Re: 19-143 Rye Park Wind Farm Modification Aboriginal Cultural Heritage Assessment

NGH would like to advise of two inconsistencies within the Aboriginal Cultural Heritage Assessment (ACHA) report, supplied by NGH to Tilt Renewables in April 2020, and Addendum report supplied to Tilt Renewables in August 2020. The inconsistencies relate to two sites in the impact assessment tables provided in the report. Below is an explanation of the issue and the change required to correct the record.

Table 2: Aboriginal heritage items – minimise impacts

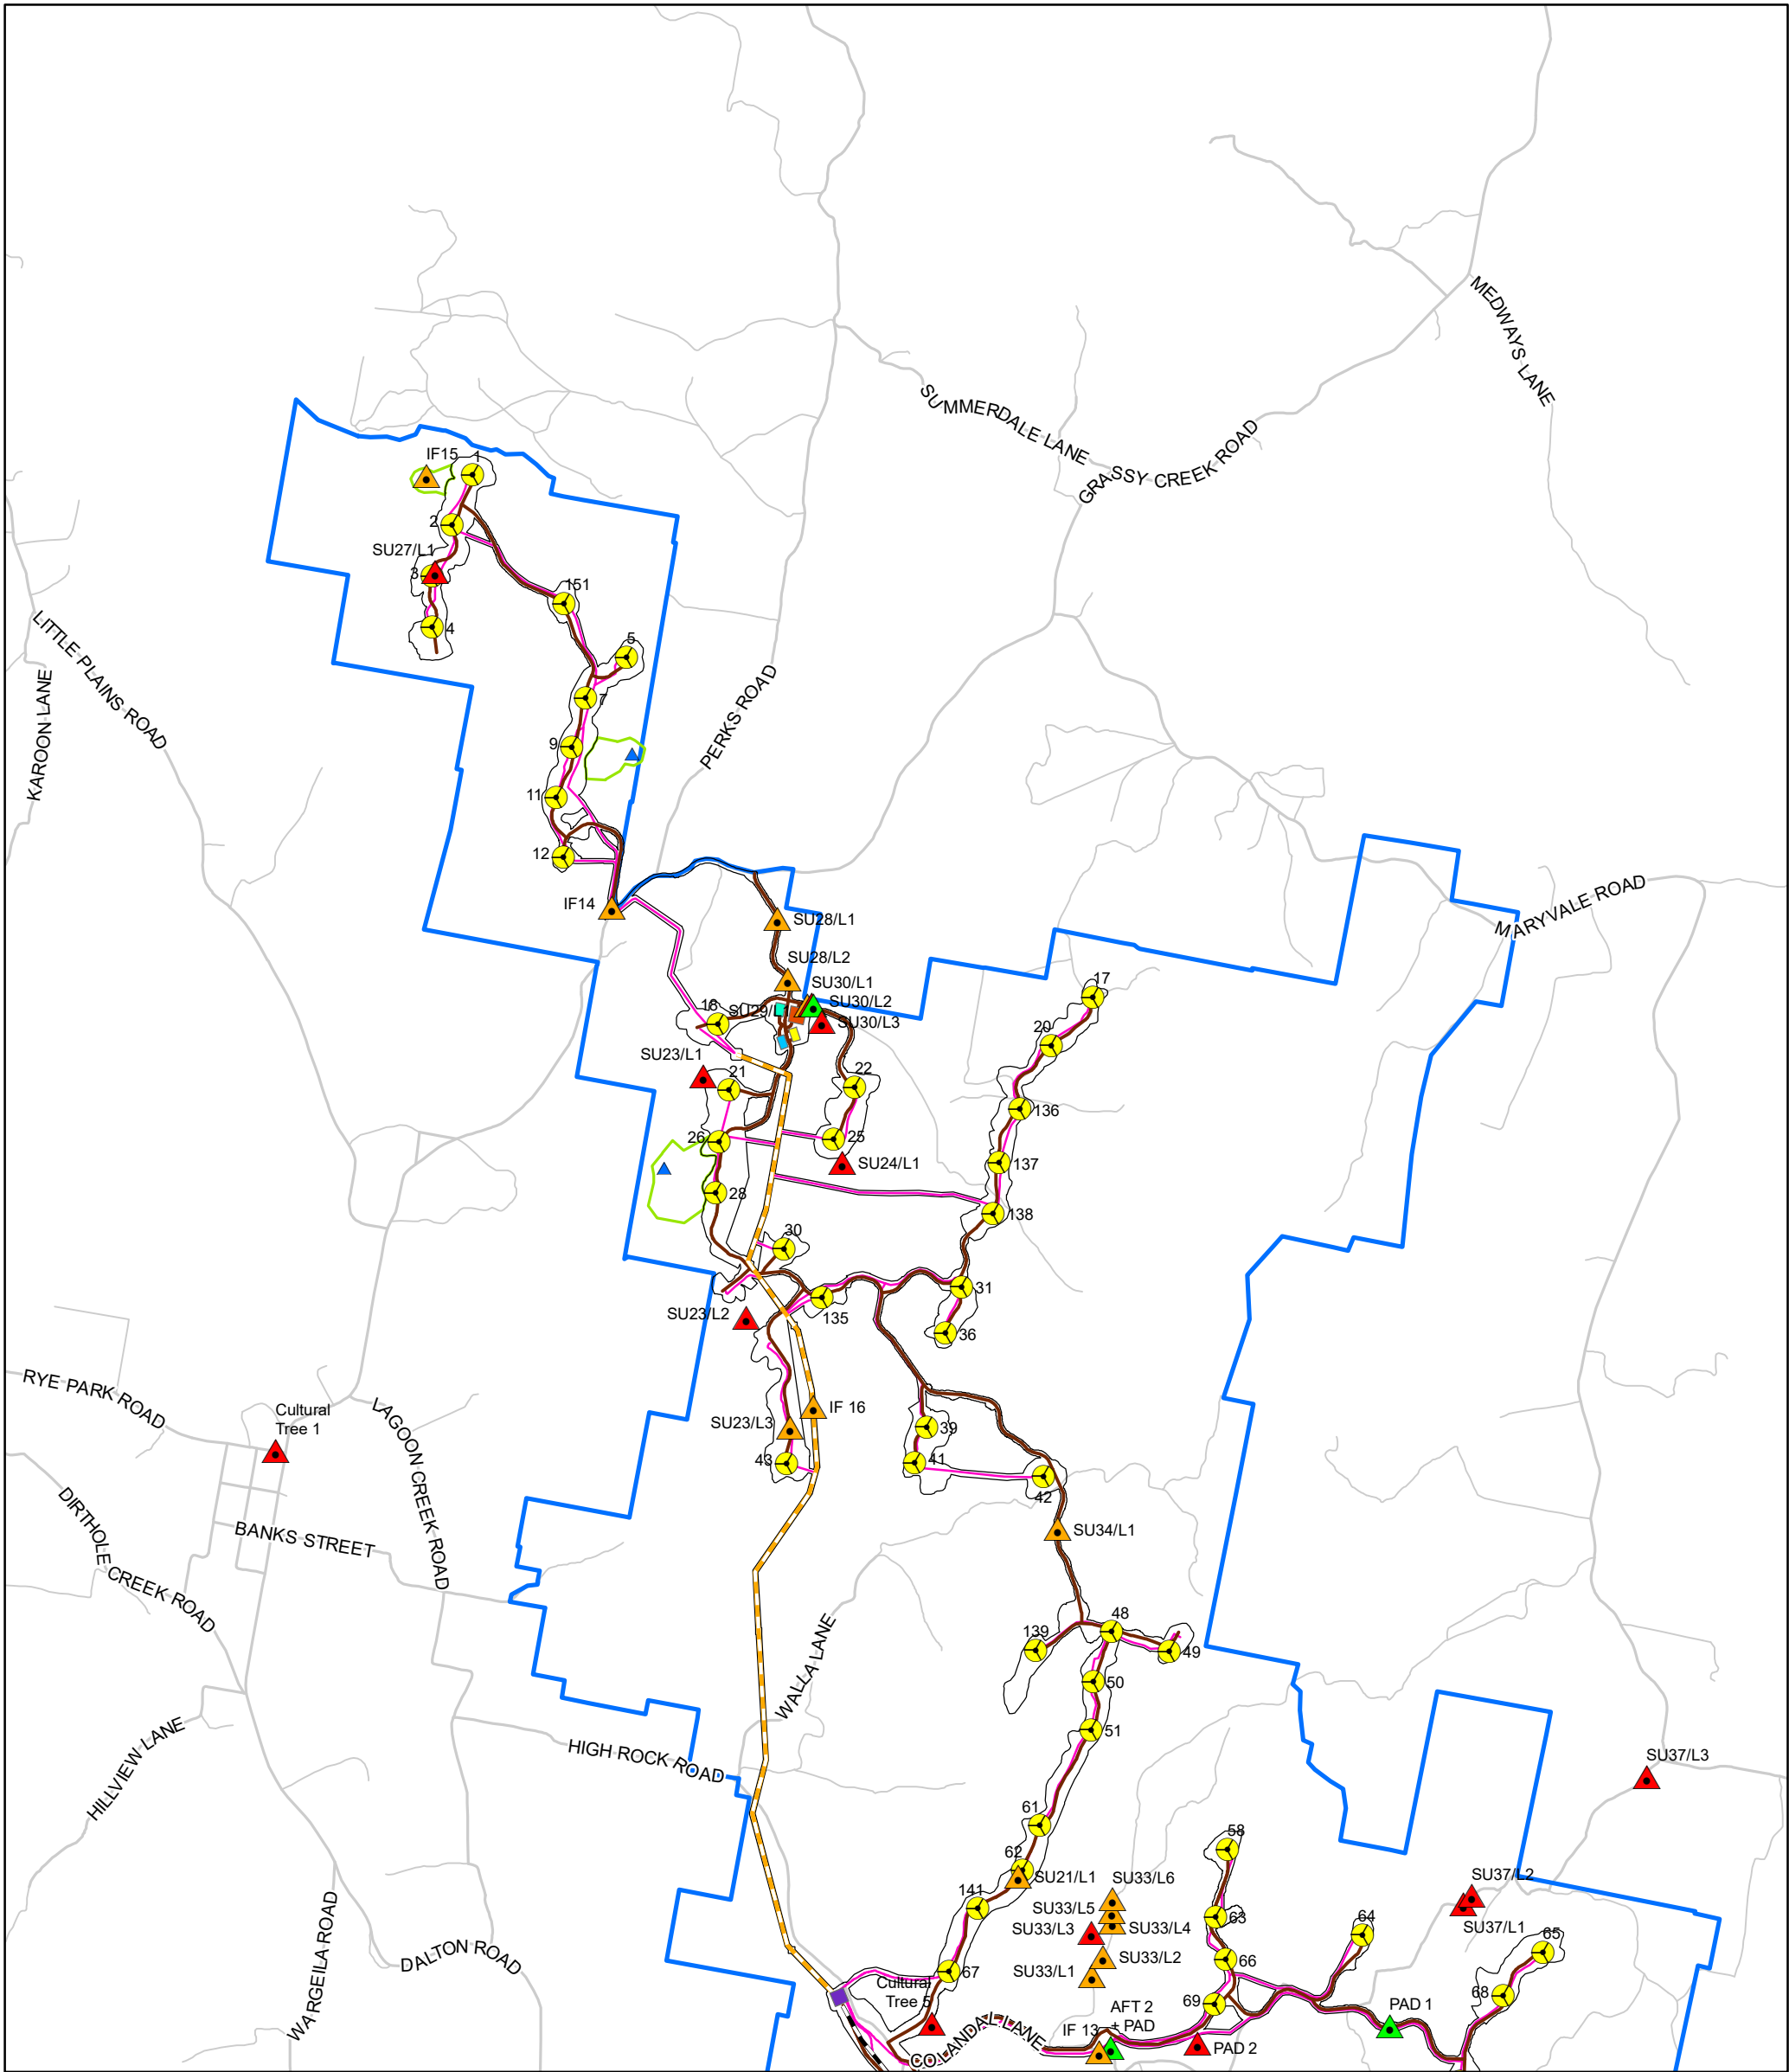
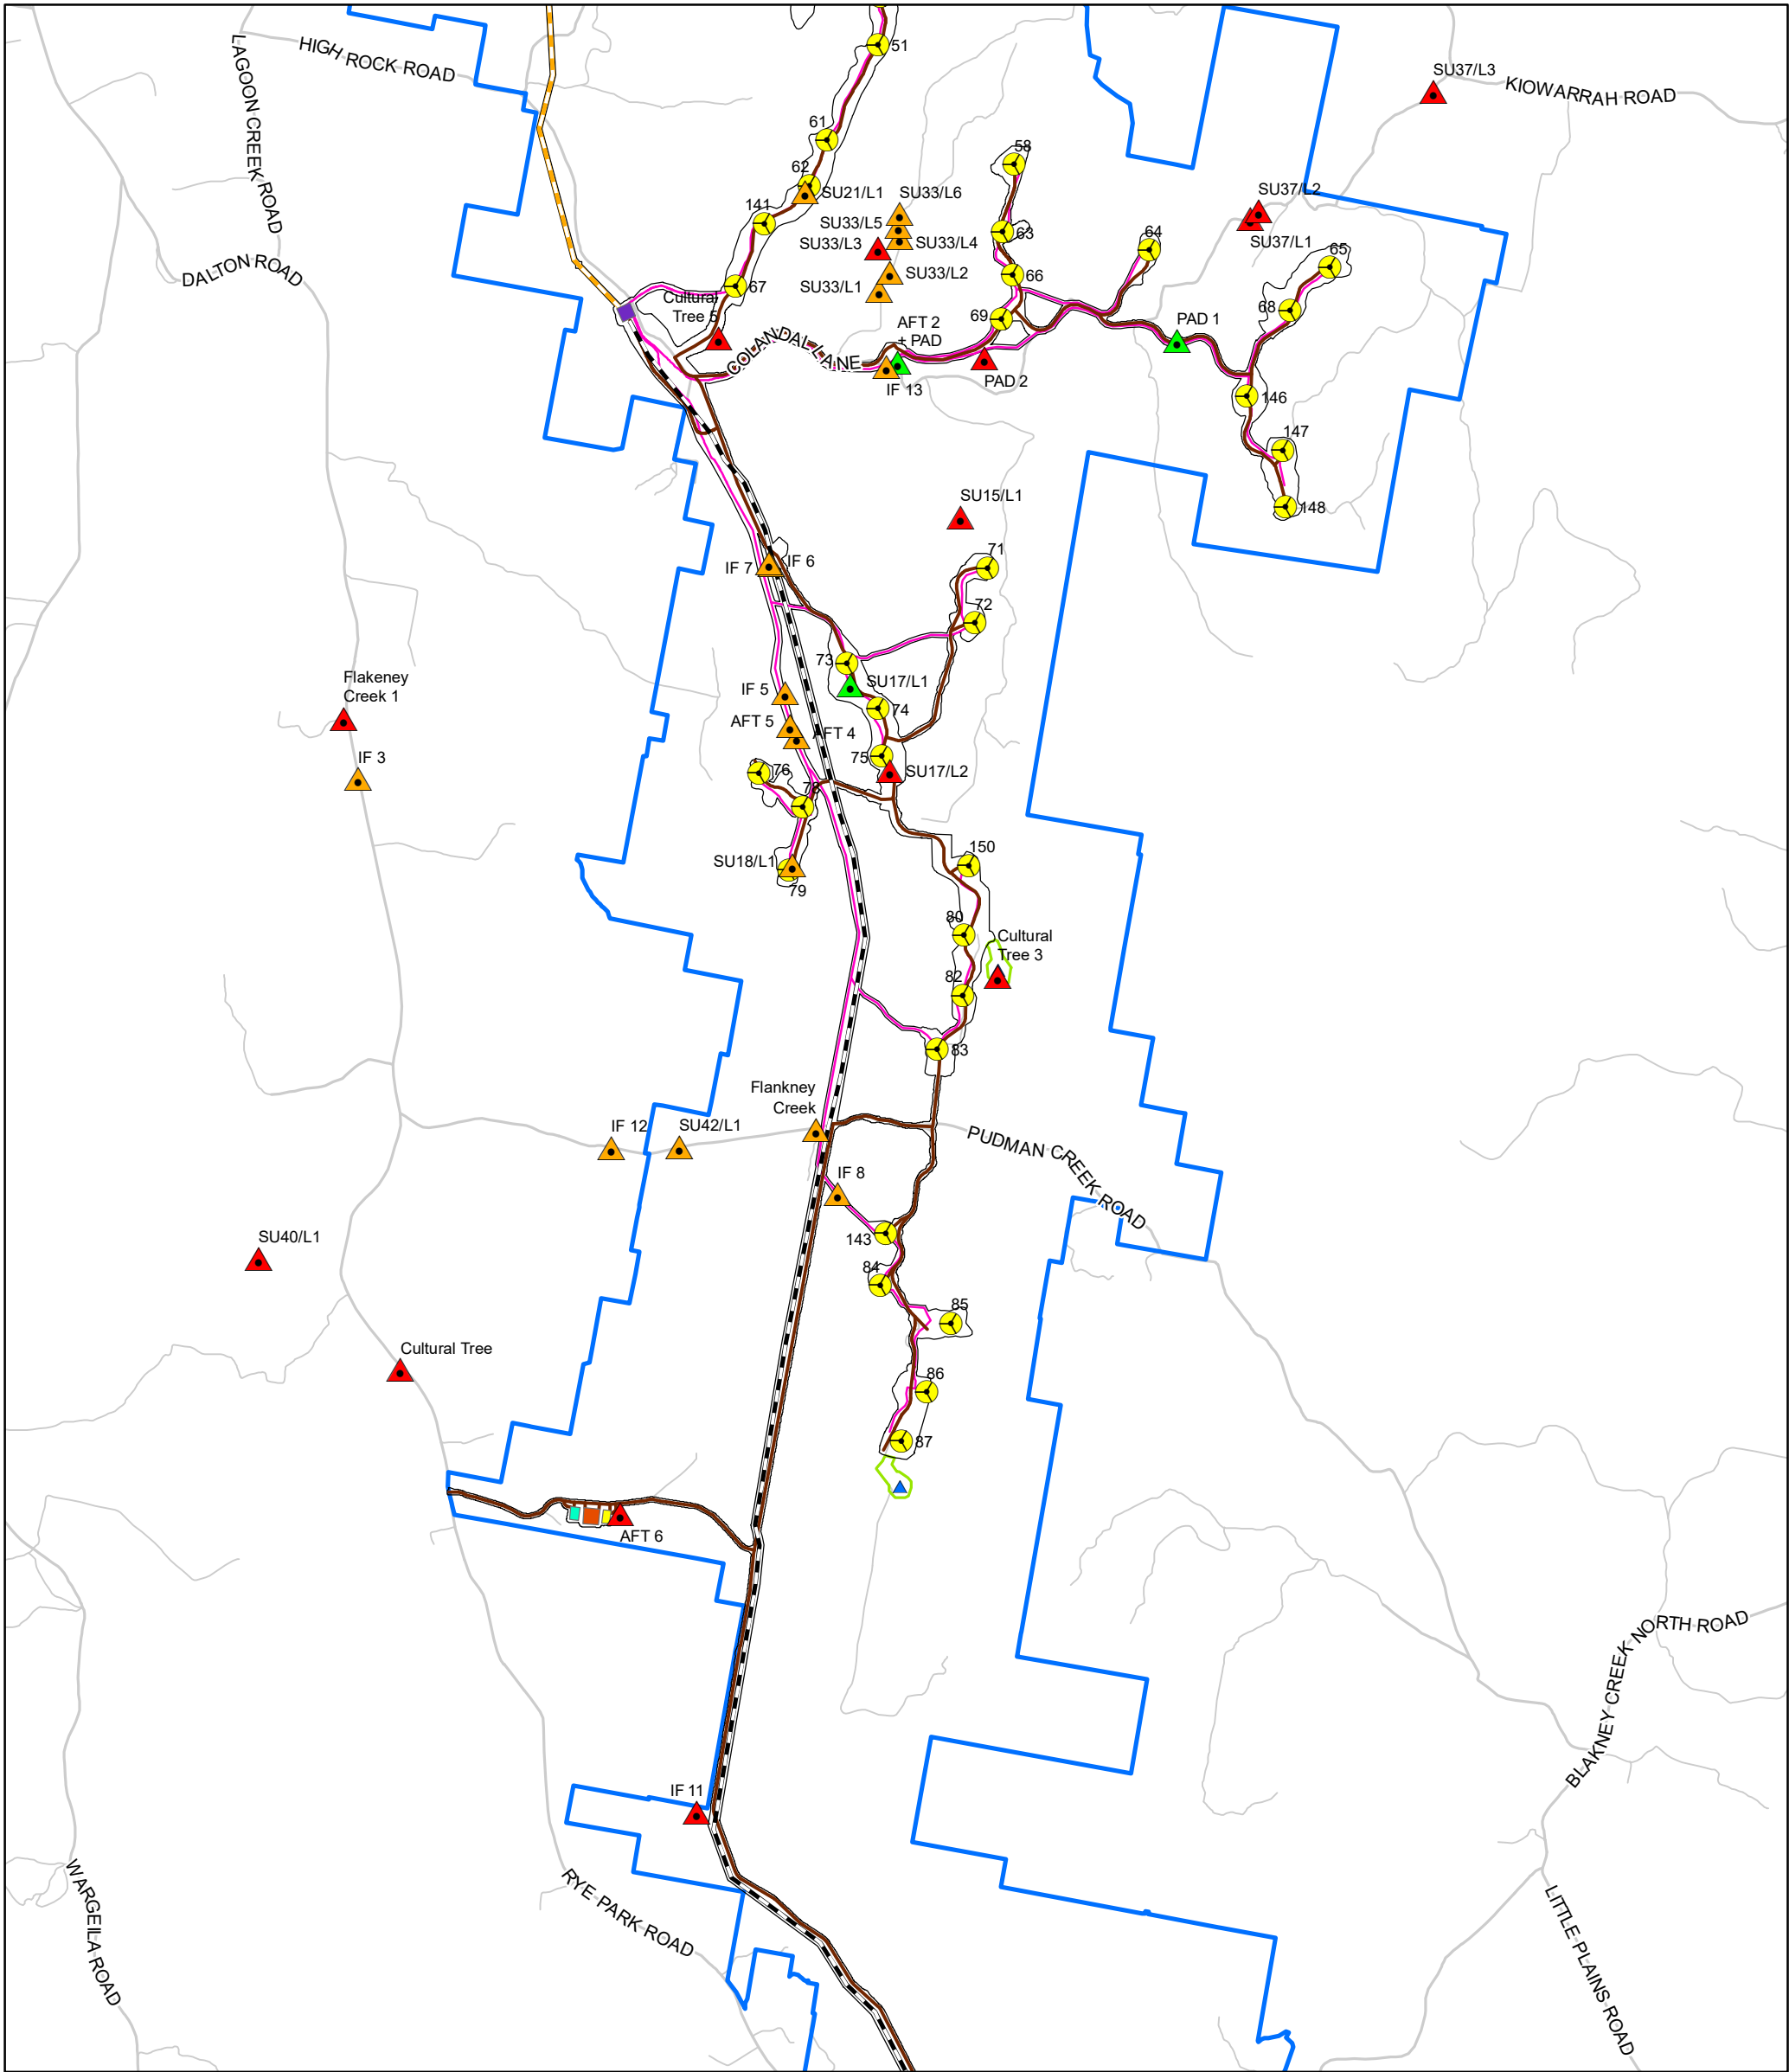
Table 7-1 (pp. 81-96) of the ACHA report (2020), outlines the identified risk to known Aboriginal heritage sites. Within this table (pg. 88), the description associated with IF10 incorrectly describes the site as including a Potential Archaeological Deposit (PAD). As a consequence, the recommendations include the need for salvage excavations at the location, if impacted. This is an error in the site type as there is no PAD associated with IF10.

This error has also been repeated in the Modification Application (submitted April 2020), where Table 3-6 *Aboriginal heritage items – excavations* also incorrectly identifies the recommendation for IF10 as Minimise/Undertake salvage excavations.

Table 3-5 *Aboriginal Heritage Items – minimise impact* of the Addendum report (pg.17), has an error in the outlined impact of site IF4. This site is an isolated surface artefact, which has been incorrectly listed as requiring salvage excavations if impacted. This is an error in the recommendations as there was no subsurface potential identified.

This error also occurs in Table 2 of the Modification Application (submitted April 2020), *Aboriginal Heritage Items – minimise impact*.

The site IF10 will need to be removed from the table *Aboriginal heritage items – excavations* and added to the table *Aboriginal Heritage Items – minimise impact*, with the impact details updated to minimise / undertake surface salvage. See updated tables below.

The site IF4 is listed in the correct table (3-5), however the details in the impact column will require updating to reflect the correct recommendation, minimise / undertake surface salvage (as shown below).
